Agency Review Comments

Trails at Aspen Ridge #2

EA-16-105

SF1927

**THE TRAILS AT ASPEN RIDGE FILING NO.2**  
 A SUBDIVISION OF A PORTION TRACT Q AND TRACT R OF THE TRAILS AT ASPEN RIDGE FILING NO.1  
 LOCATED IN THE WEST 1/2 OF SECTION 9,  
 TOWNSHIP 15 SOUTH, RANGE 65 WEST OF THE 6TH P.M.  
 EL PASO COUNTY, COLORADO  
 SHEET 2 OF 4

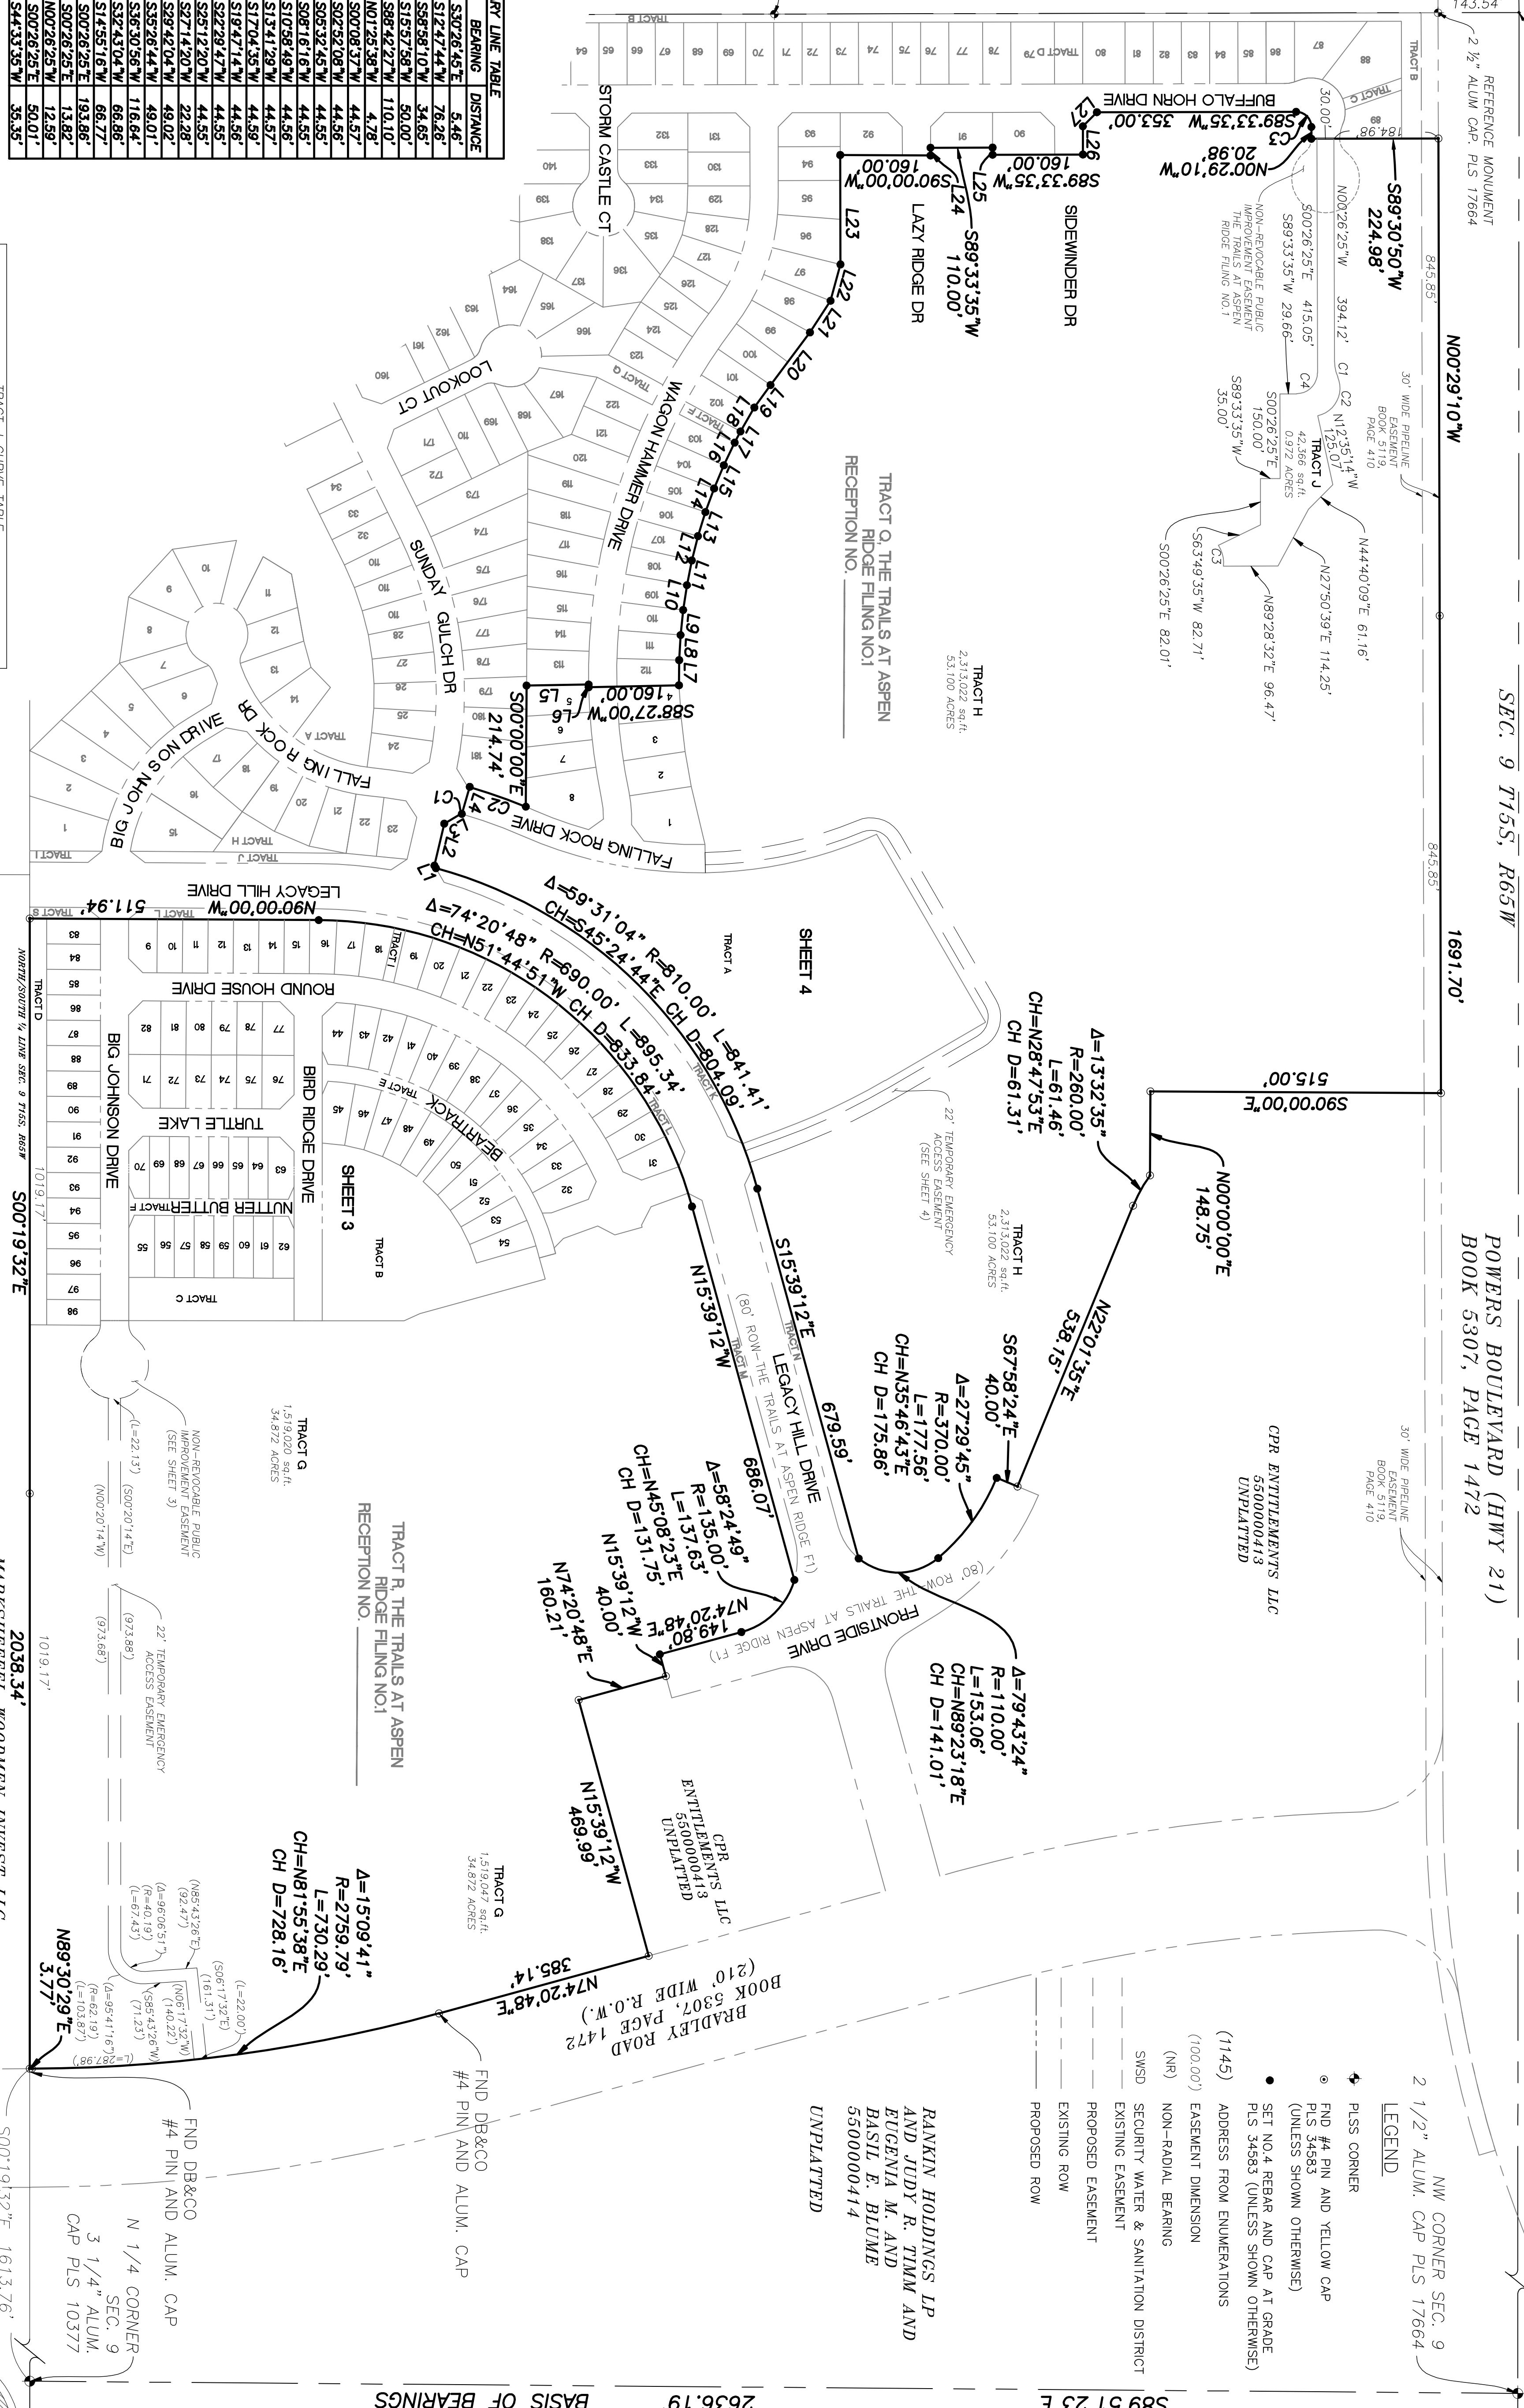
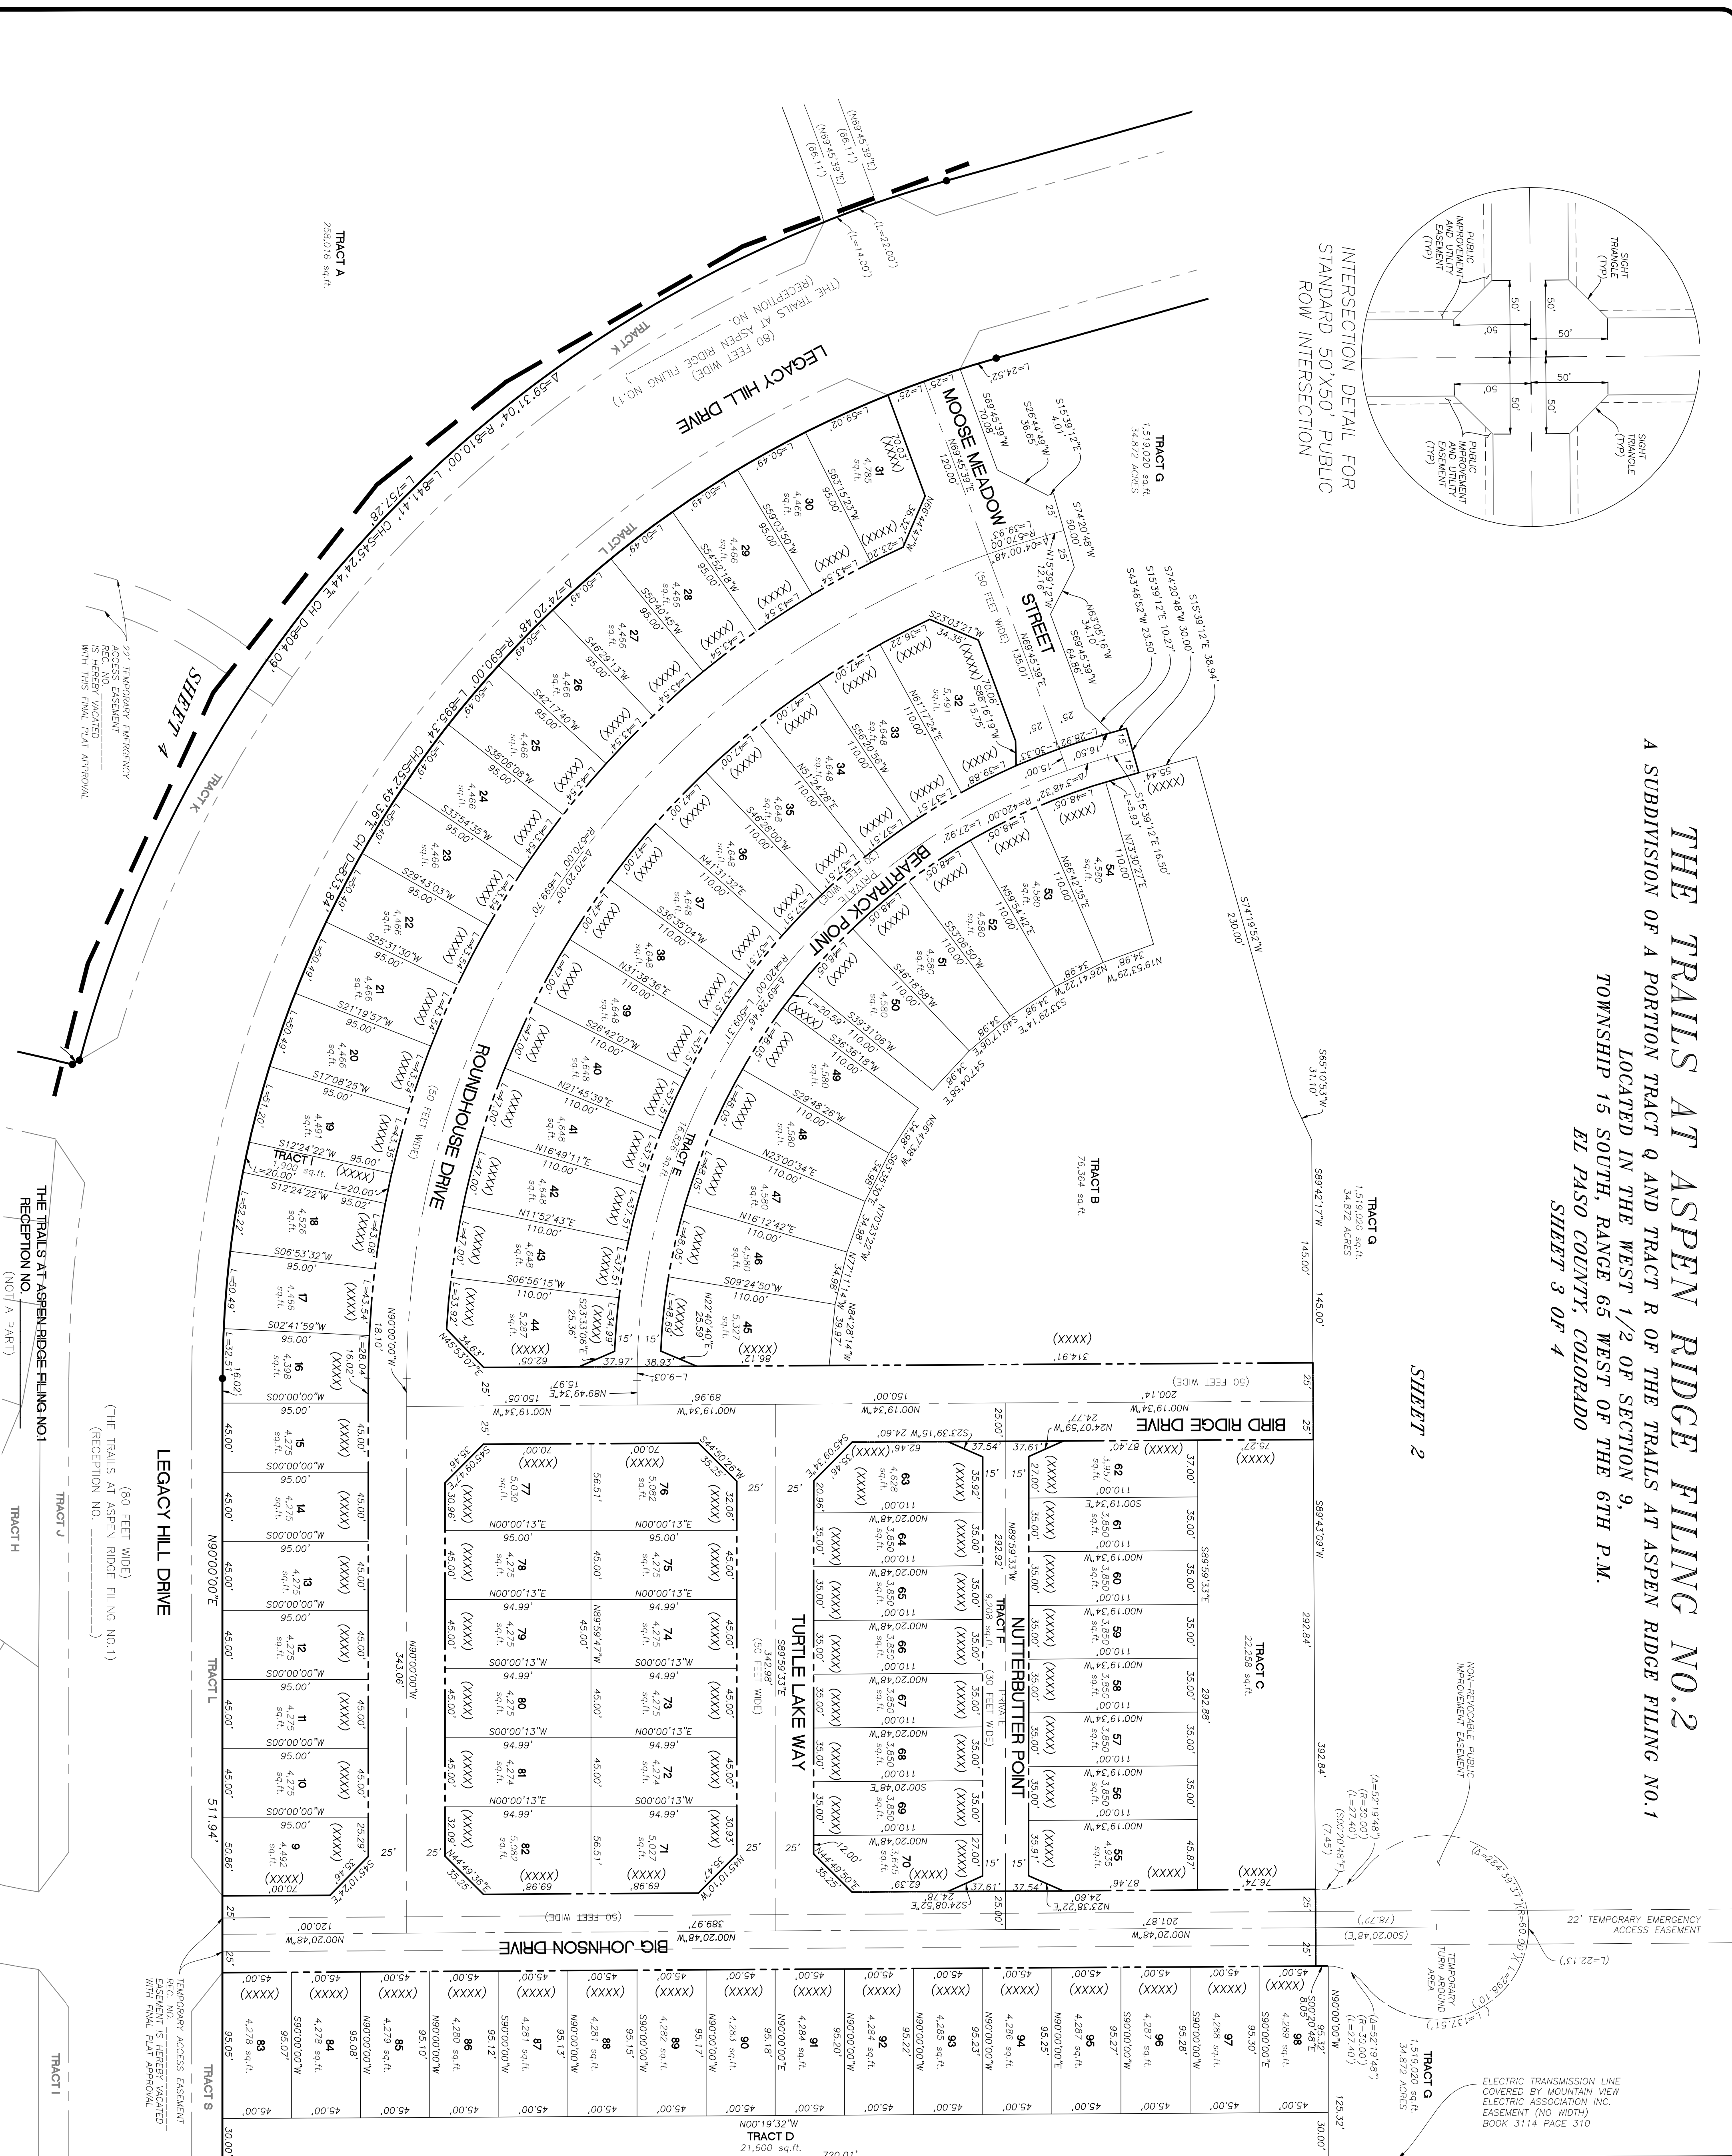
Pikes Peak Regional Building Department	Regarding a request for approval of a final plat for The Trails at Aspen Ridge Filing No. 2, Enumerations has the following comments: 1. One of the street names shown on this plat, Nutterbutter Point, is on the list of approved street names sent to us by Justin Annan at El Paso Teller 911. However, the street suffix Point is used to designate private streets, not public ones. Verify with Justin that the use of this suffix is OK, or if it should be changed to a suffix used to designate public streets such as Drive, Street, or Road. 2. Submit a copy of this plat to Enumerations for addressing. Show the location of the front doors for the houses on each lot, particularly Lots 32-44 and 63-70 where there is a street on both sides of the lots. 3. Plat note 12 states that there is no direct access to Legacy Dr., but, the street name is shown as Legacy Hill Dr. Correct the plat note to show the correct street name. 4. Enumerations will review the mylar prior to plat for address placement, street names, and title block. Noted. Thank you. 5. \$10.00 per lot & tract platting fee will be due at the time of the review of the mylar (2 addresses per lot & tract). If an address is not needed on a tract then no fee applies. Check should be made out to PIKES PEAK REGIONAL BUILDING DEPARTMENT or PPRBD. Paid directly to the Enumerations Department. Noted. Thank you. 6. A copy of the final recorded plat is required prior to plan submittal for RESIDENTIAL. A copy of the final recorded plat is required prior to approval in the Enumerations department on any COMMERCIAL plan submittal. Amy@pprbd.org or Brent@pprbd.org Brent Johnson Enumerations Plans Examiner Pikes Peak Regional Building Department O: 719-327-2888 E: brent@pprbd.org W: pprbd.org	12/30/2019 9:02:38 AM Nutterbutter Point is a private street. This has now been indicated on the plat. Street name has been corrected on the plat Noted. Thank you.
